EMBREY BUILDERS, LLC.

RFI

RFI #: 56
Date: 2/20/2012
Job: EB-02 Keller Springs Lofts
Phone: 877-777-5115

Subject: Party Walls

**S2.36**

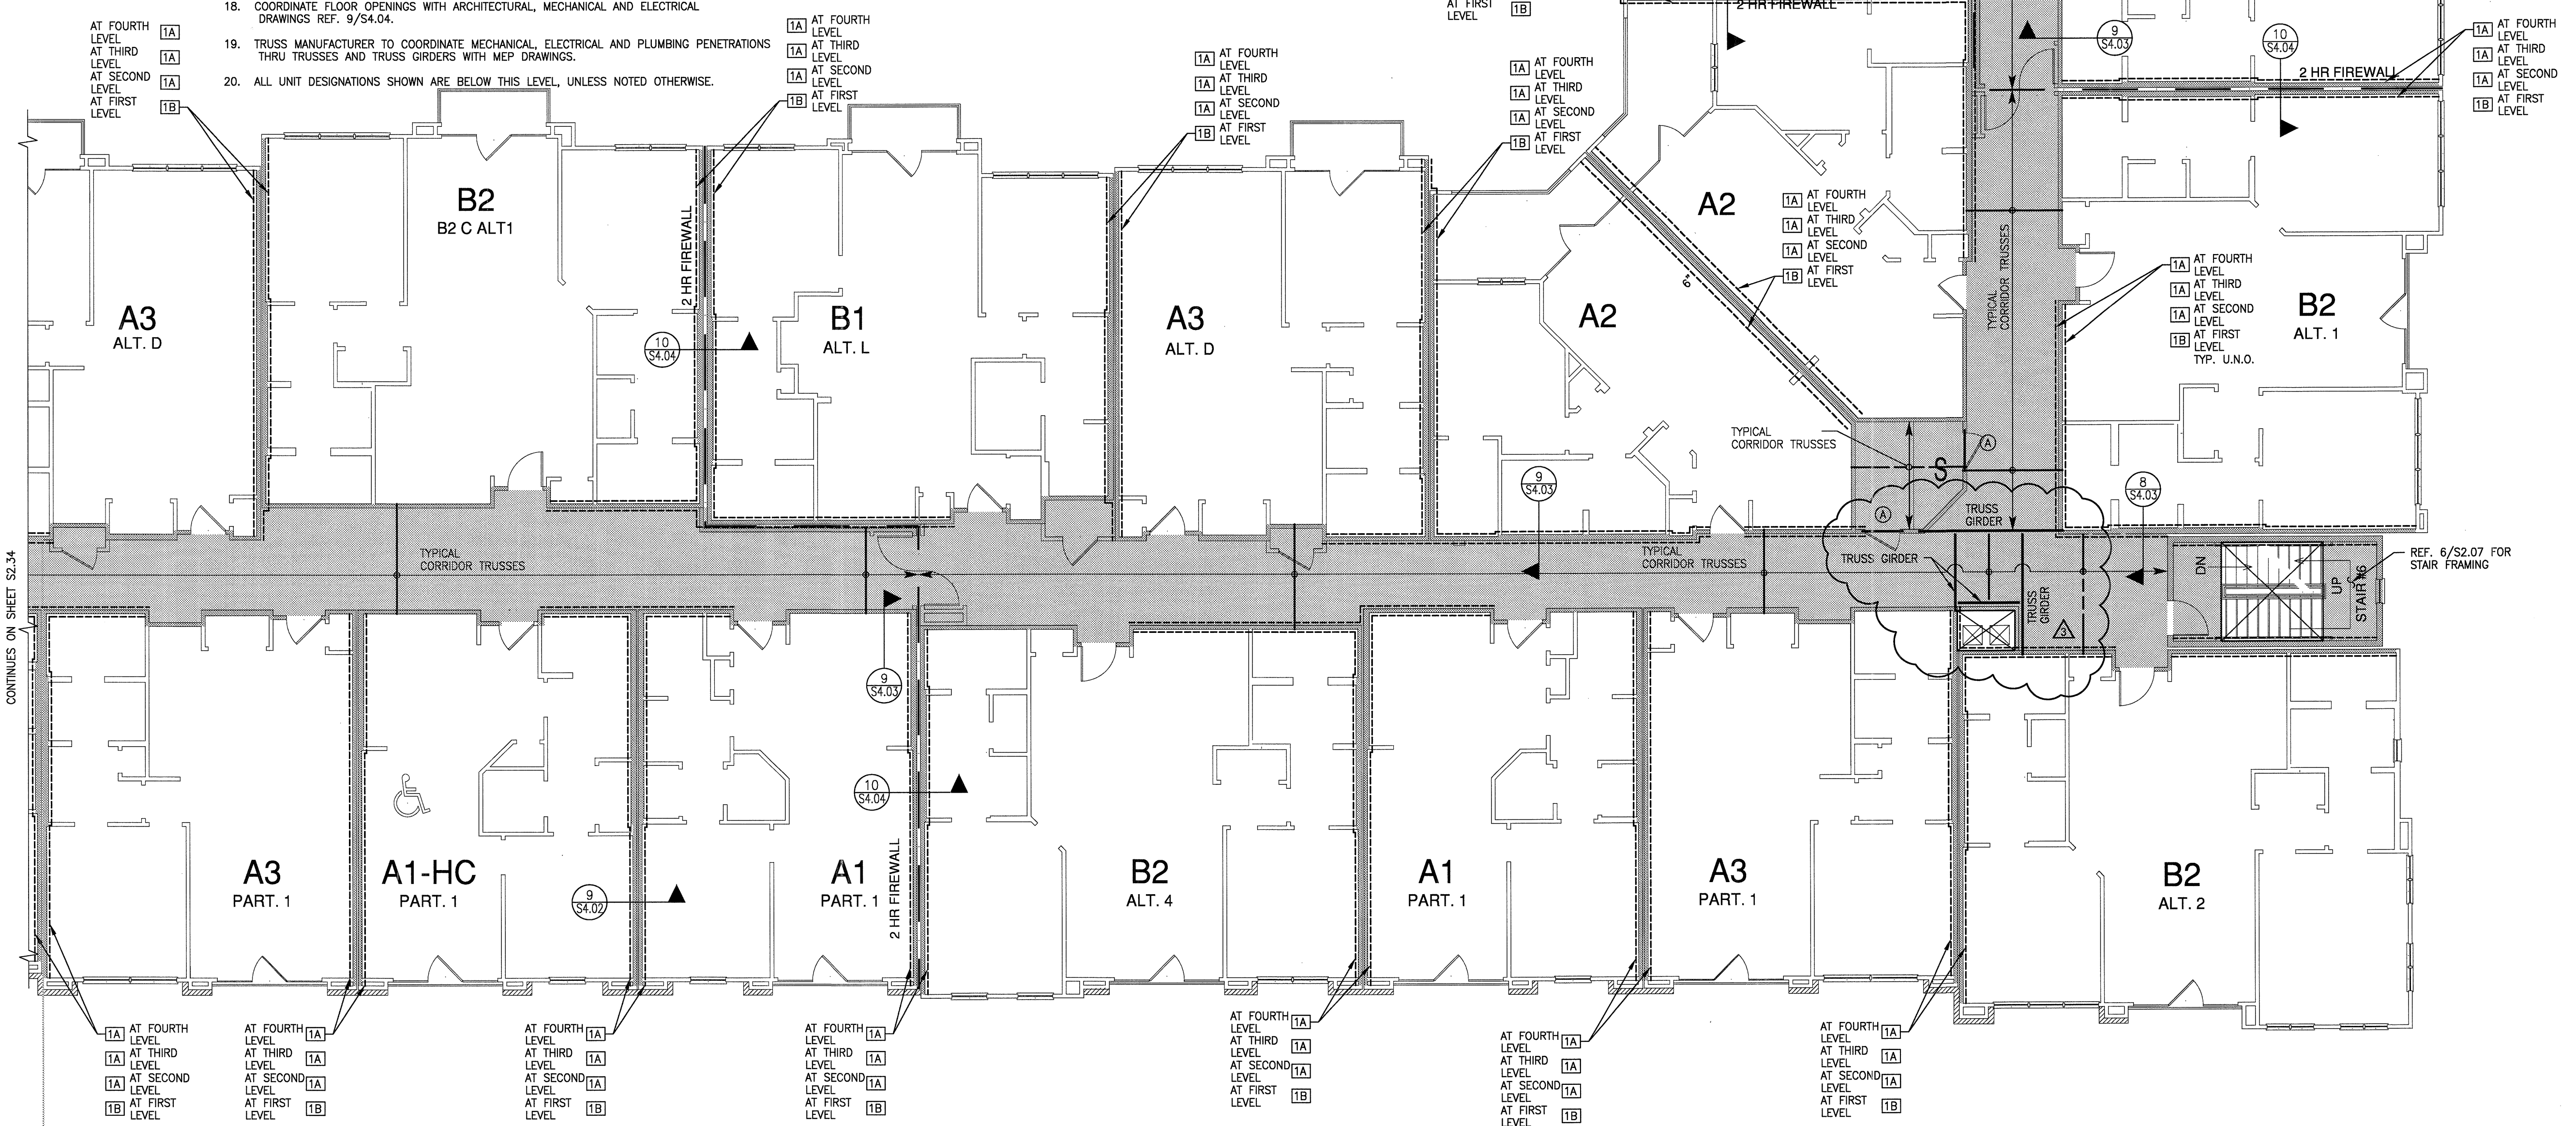
Details 1 & 2 on page 7.1 of the architectural drawings shows the wall make up to have 1 sheet of plywood in the middle of the double walls. The note tells us to refer to the structural drawings for the nailing pattern. Pages S2.31 through S2.36 gives us the shear wall designations. Our shear walls are types 1A & 1B. The shear wall schedule on page S1.03 tells us that the shear wall sheathing on types 1A & 1B is 1 layer of 5/8 gypsum wall board applied to 1 face of the wall. I cannot find where the shear wall schedule requires 15/32 plywood as a component of the double party walls. There are some details in the structural drawings on page S4.02 that show 15/32 sheathing but again it is not noted as a structural component. Please confirm that this was the correct understanding or not. (Is OSB required as part of the double party wall make up?)

The 15/32" APA Rated Sheathing (noted in the Architectural drawings and in details 9, 10, and 11 on sheet S4.02 and details 5, 6, and 7 on sheet S5.01) is not part of the shear-wall assembly.

If the contractor provides adequate temporary bracing of the structure, the sheathing is not required structurally.
